SITE 4B SYDNEY OLYMPIC PARK

ACCESS REVIEW

Morris-Goding Accessibility Consulting

22nd January 2007

Floor Plan
Basement Level 002-003

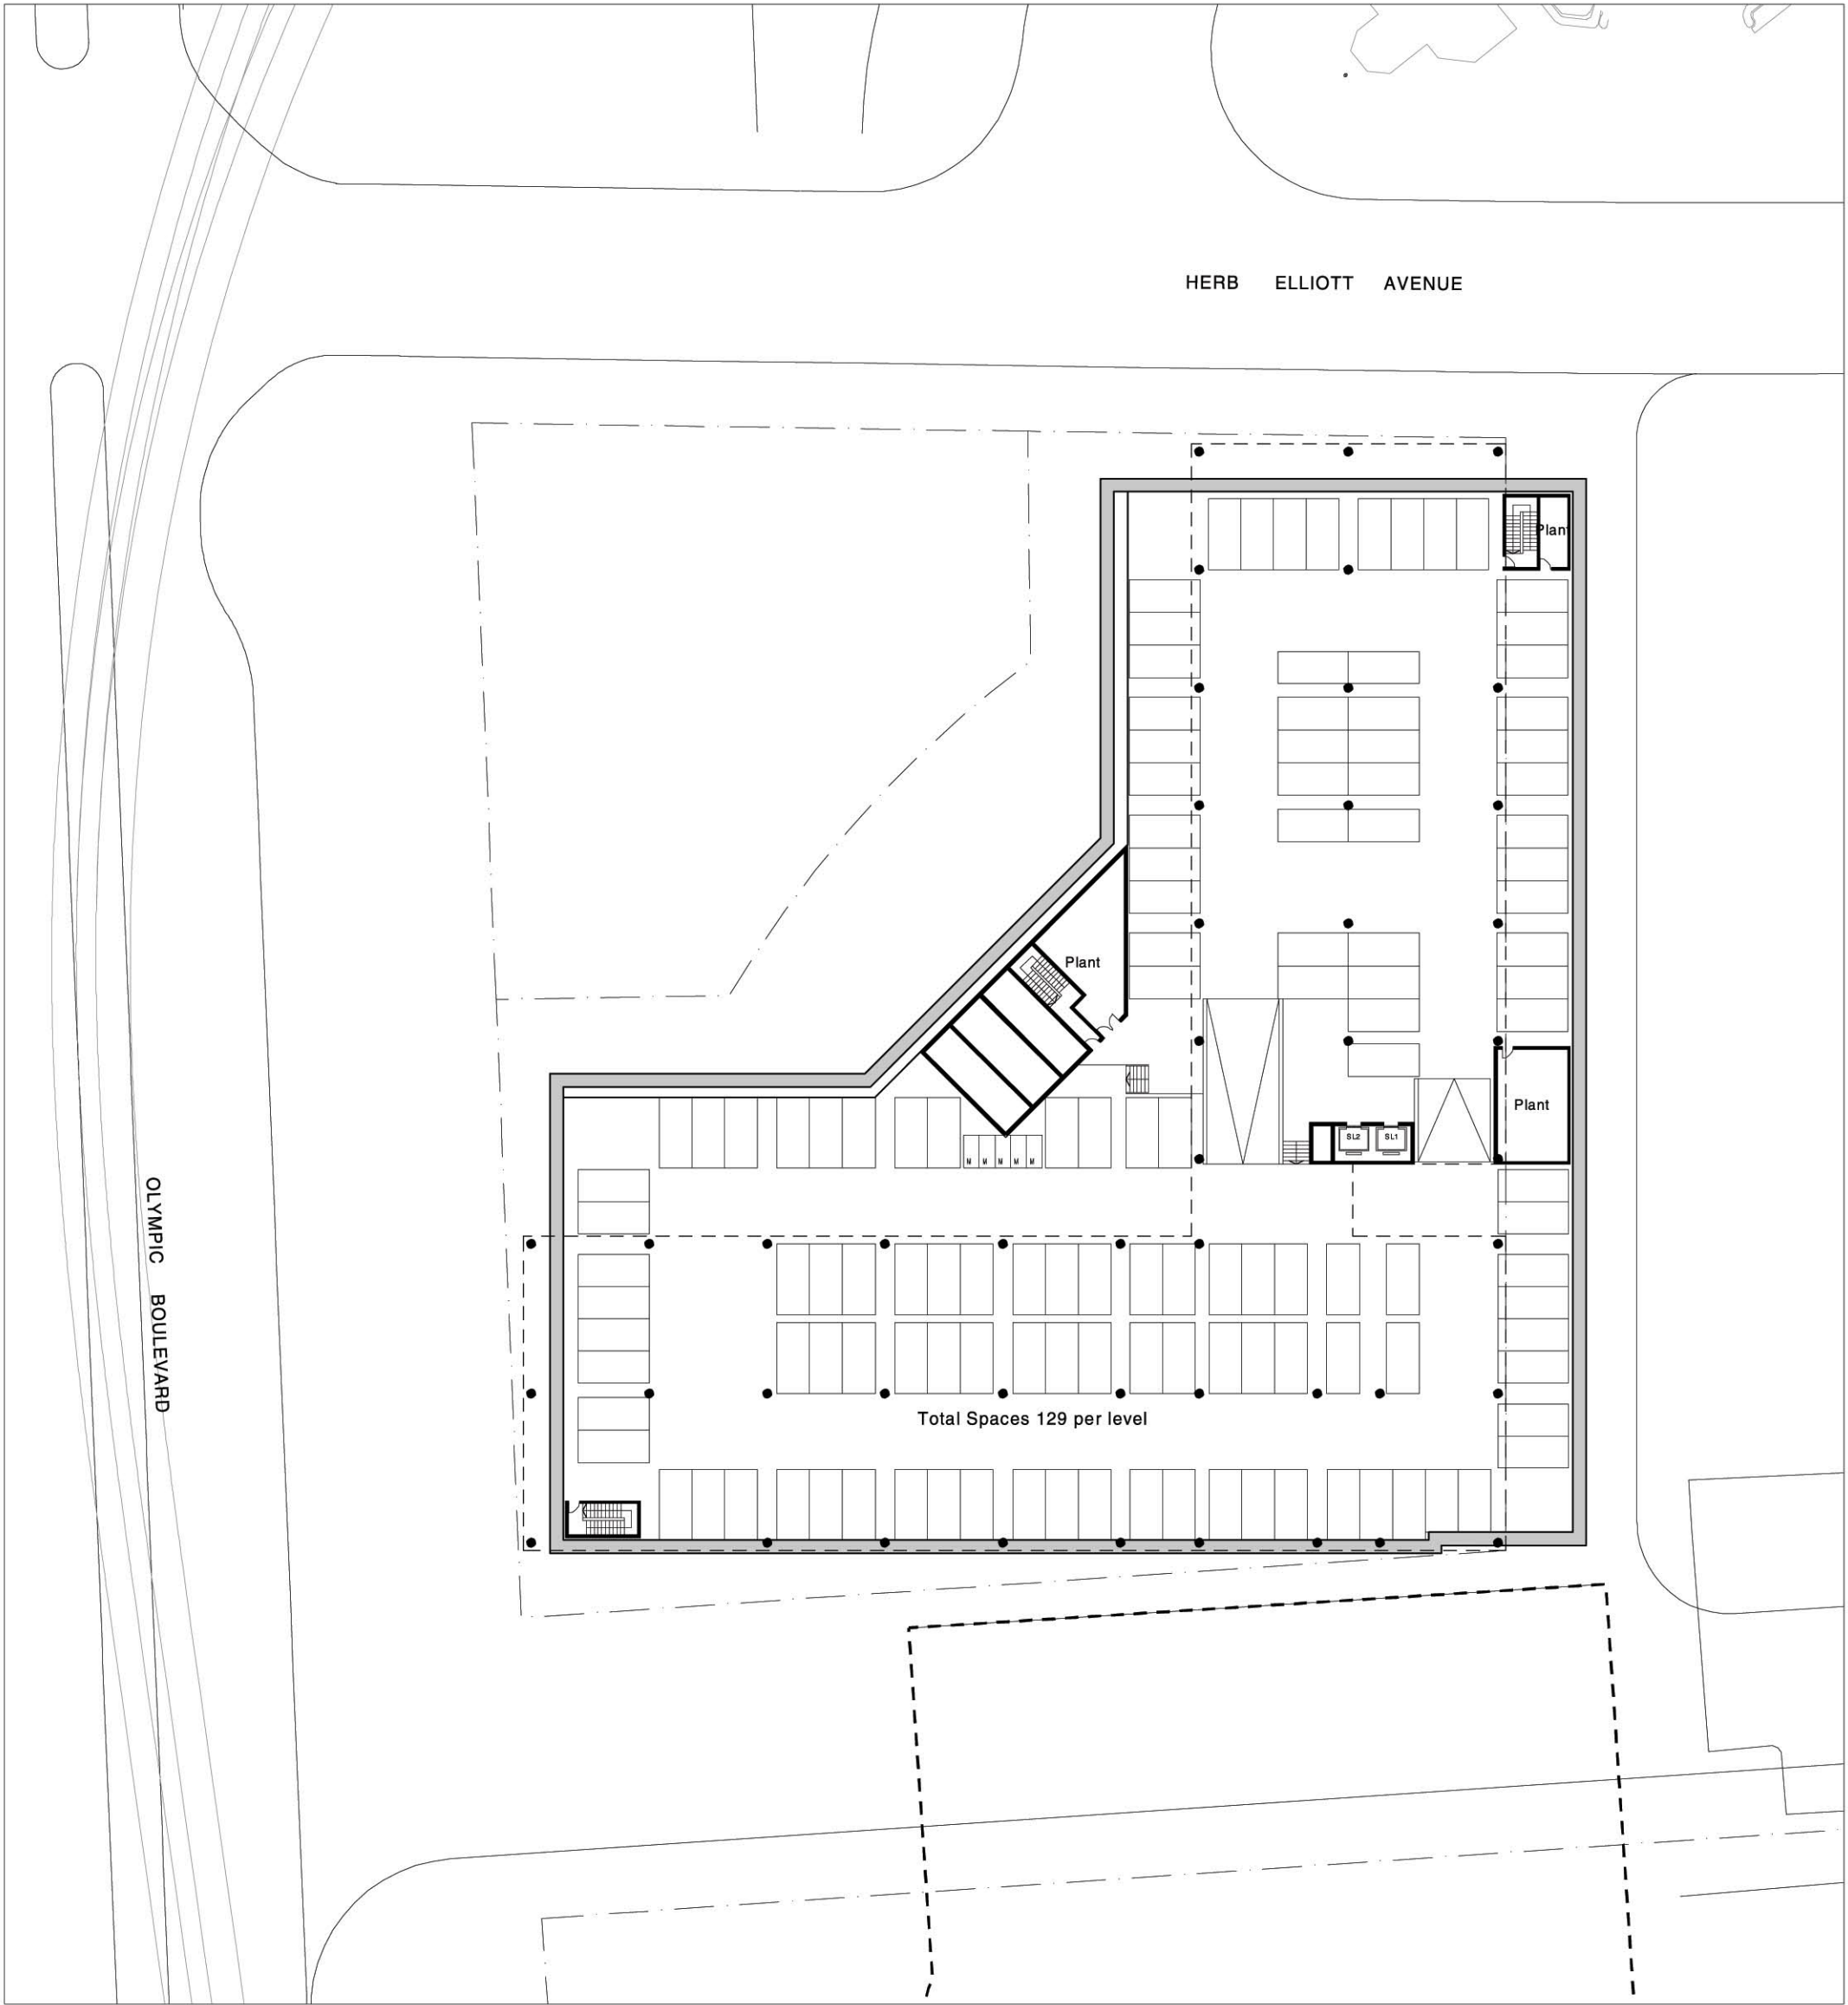
There are 3 basement levels of car parking available within the building, with approximately 362 car spaces. No accessible car bays have been designated.

- (i) Provide 1-2% of total car bays to be designated as accessible.
- (ii) Ensure the accessible car bays have widths of 3.2m and lengths of 5.5m.
- (iii) Ensure the accessible car bays have a vertical clearance of 2.5 metres and a vertical clearance of 2.3 metres leading up to the bay.
- (iv) Ensure there is a safe and accessible path of travel to the lifts from the car bays.
